**Planning Department  
Transportation Development Services**

March 17, 2015

**Re: La Cumbre – Patio Addition**  
**3313 Girard Blvd., NE**  
**Traffic Circulation Layout**  
Engineer's/Architect's Stamp dated 3-6-15 (G16-D103)

SHARED
PARKING
DIAGRAM

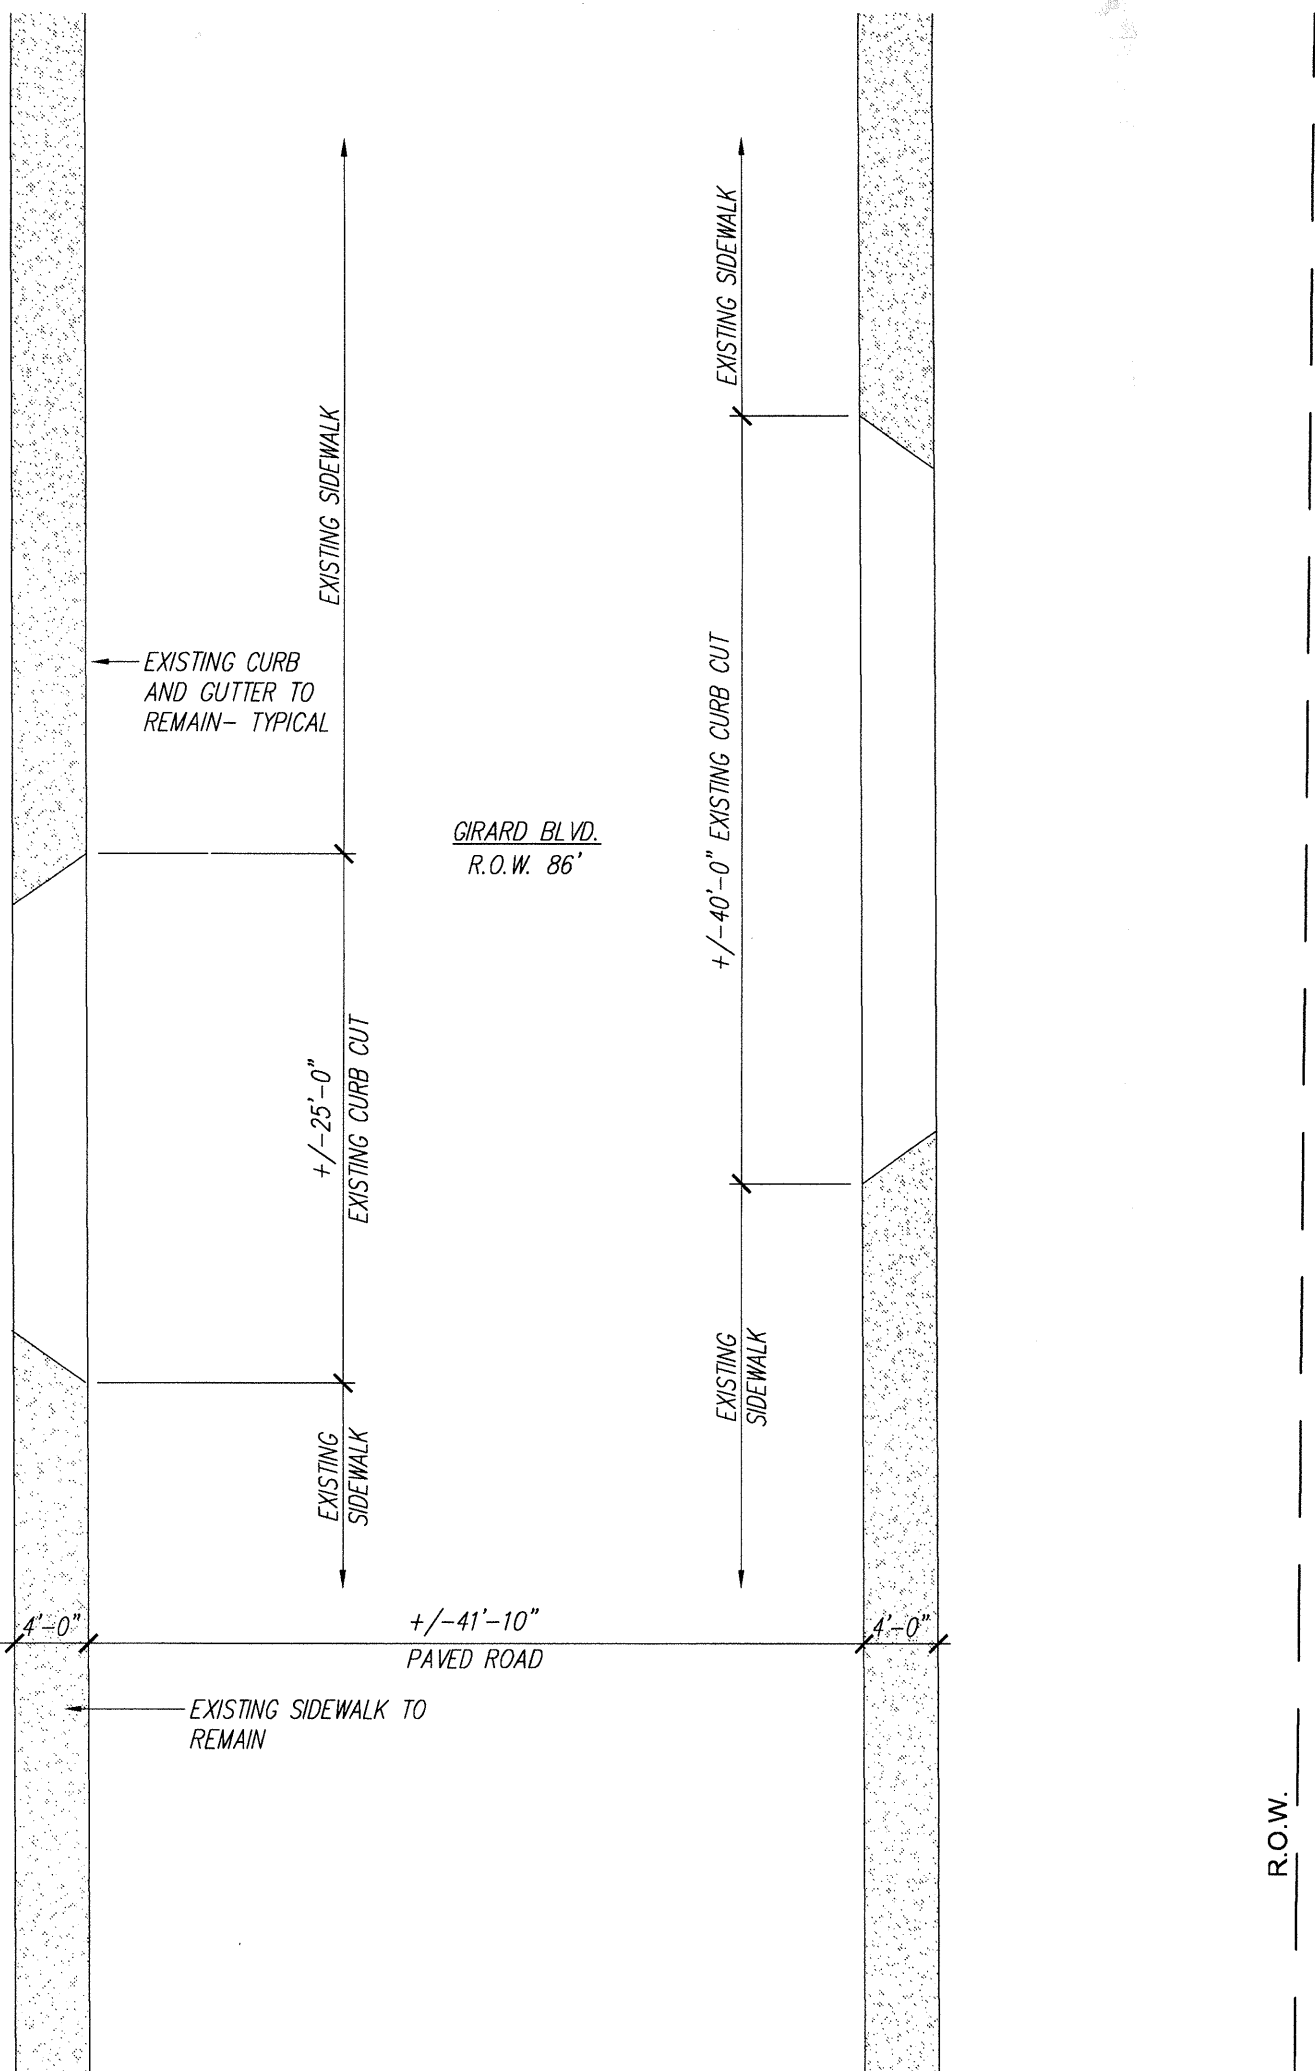
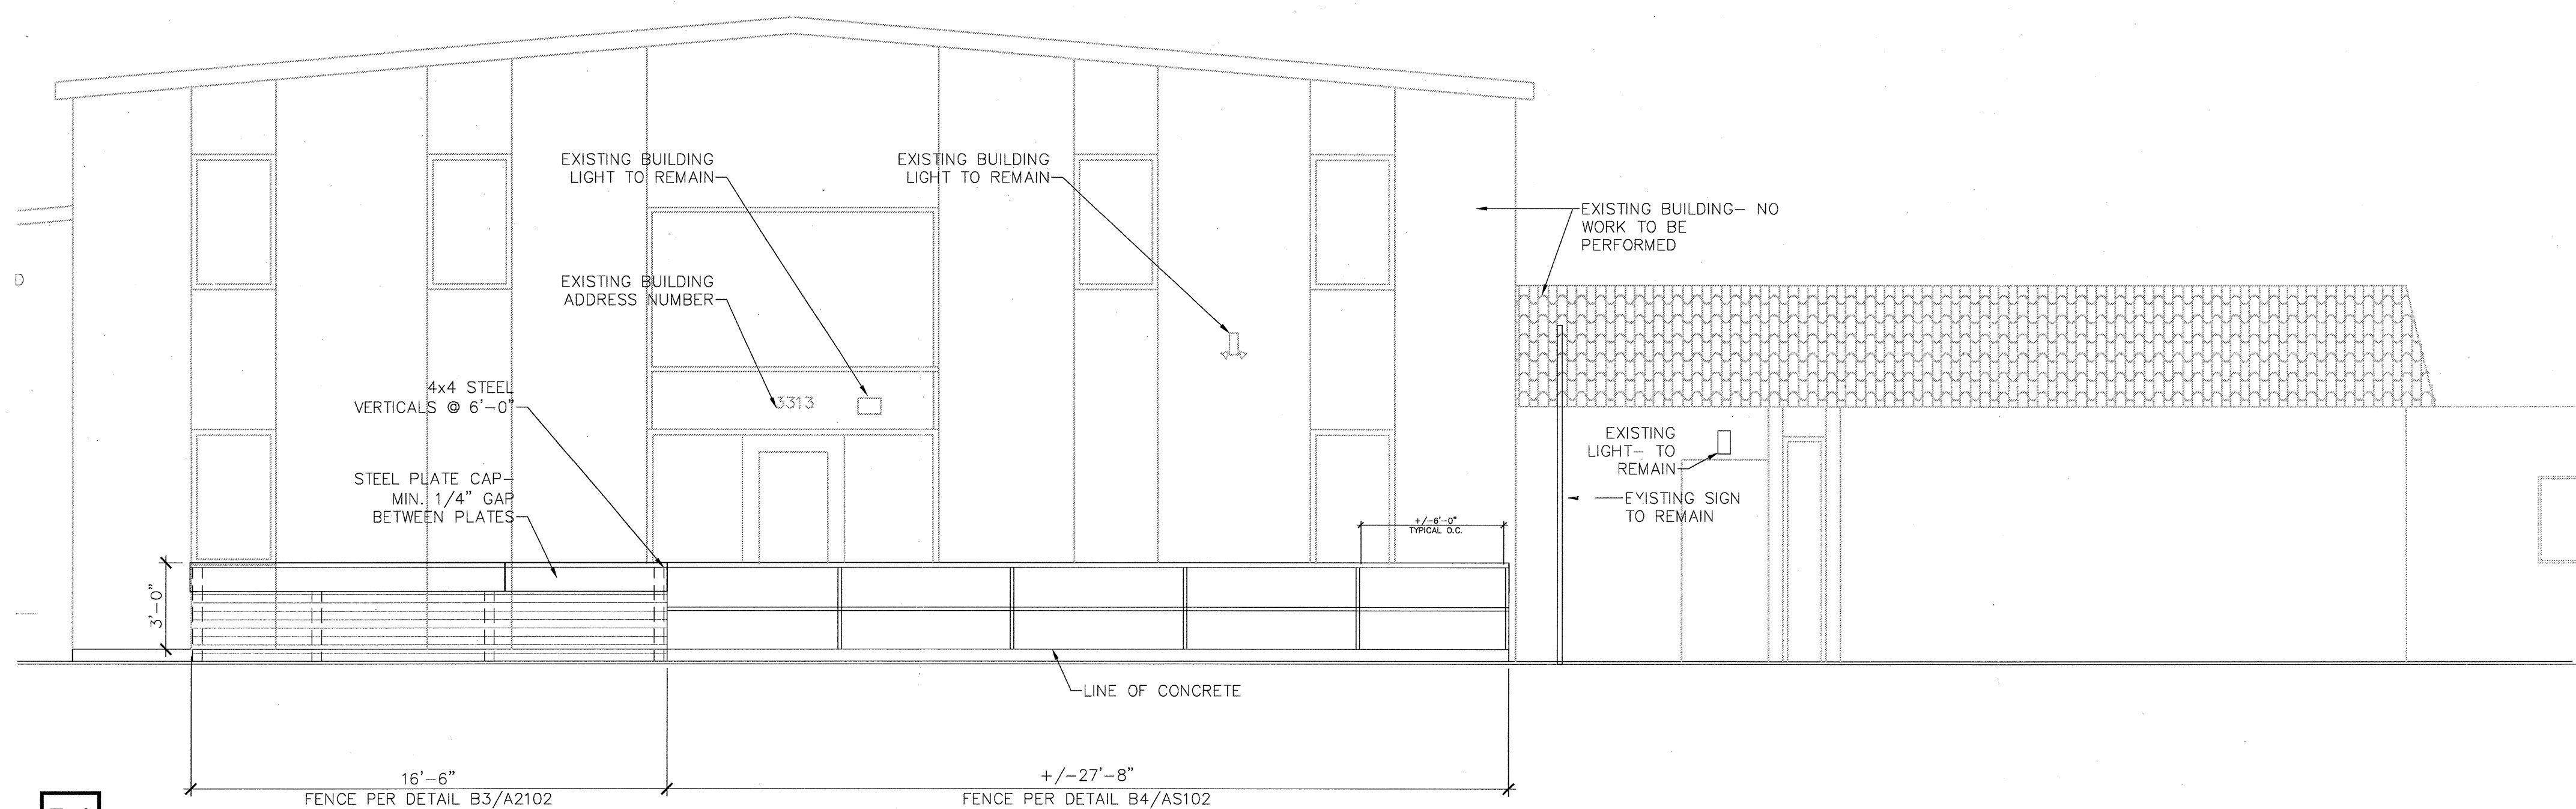
5. Please list the width and length for all parking spaces for the 3225 Girard Blvd. location.
6. The handicap accessible spaces must include an 8-foot wide van access aisle; all other aisles should be 5 feet in width.
